**Addendum No. 1**

RE: Contract # C203955

**Craven County (R-5516)**

Interchange From US-70 To Slocum Road At The Cherry

SHEET NO.
X-44

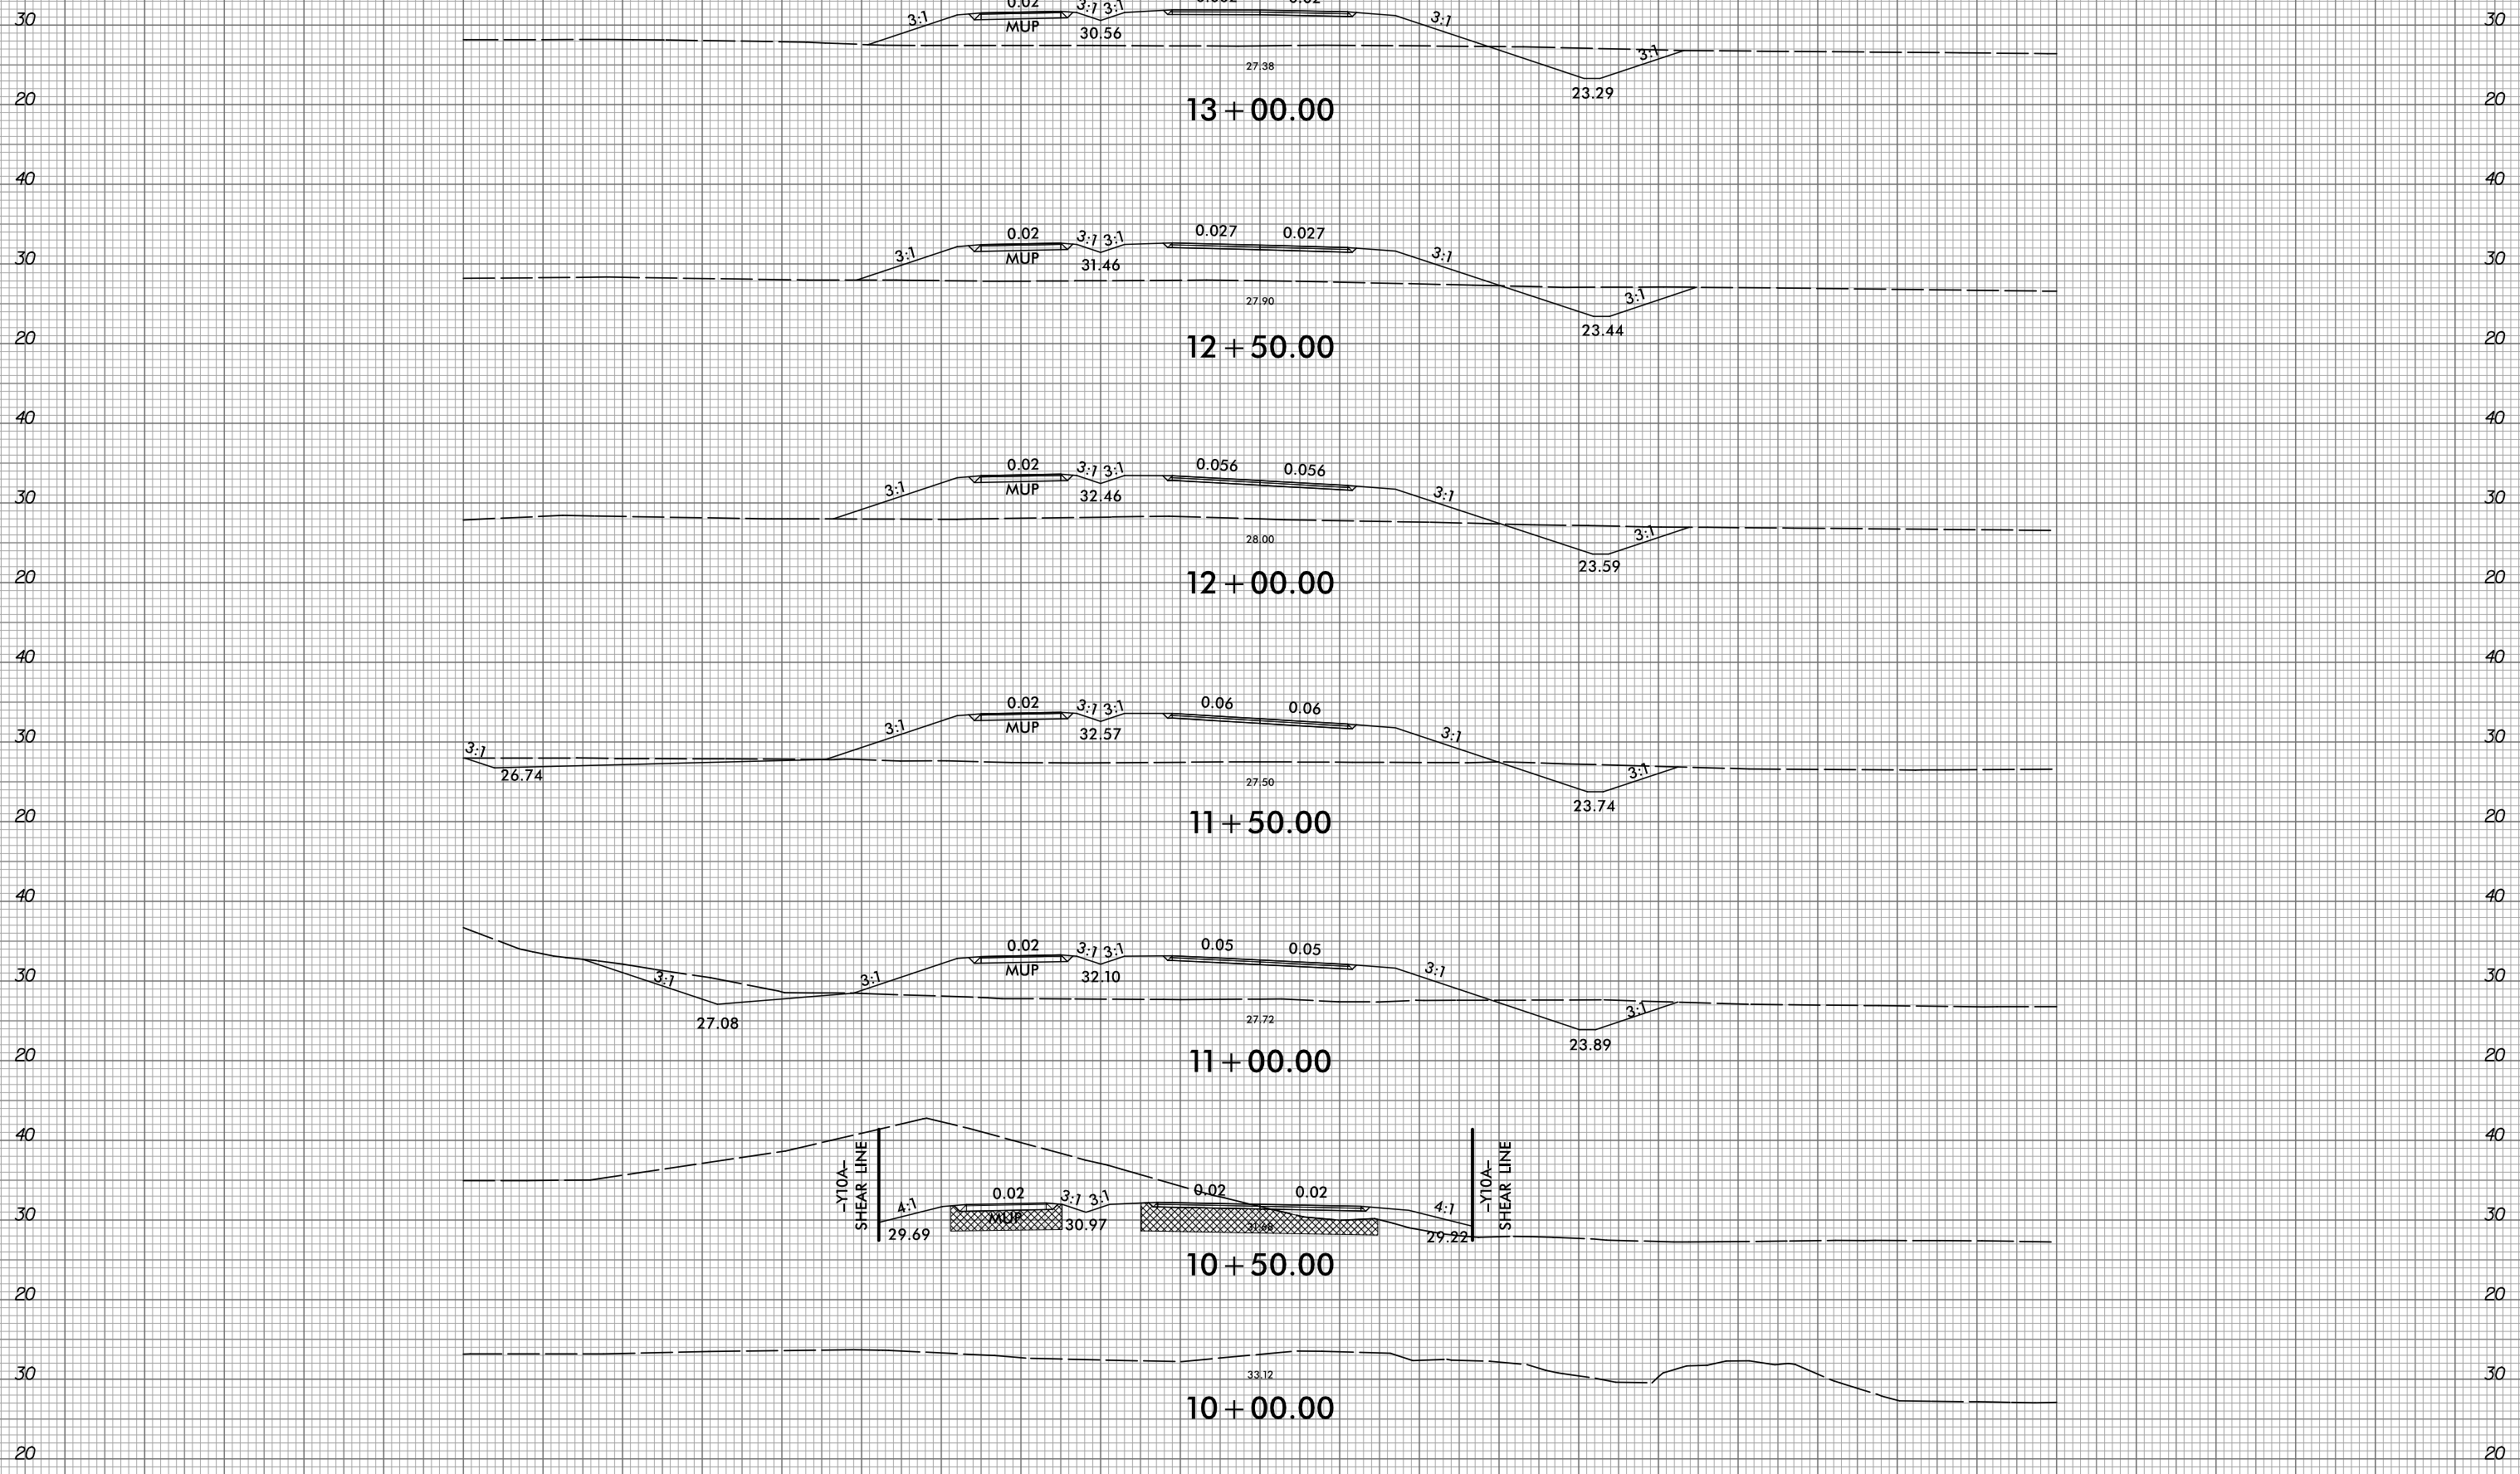
Sheet No.	Revisions
X-0B and X-44 thru X-50	Revised to correct the Undercut figures associated with Line -Y09A-
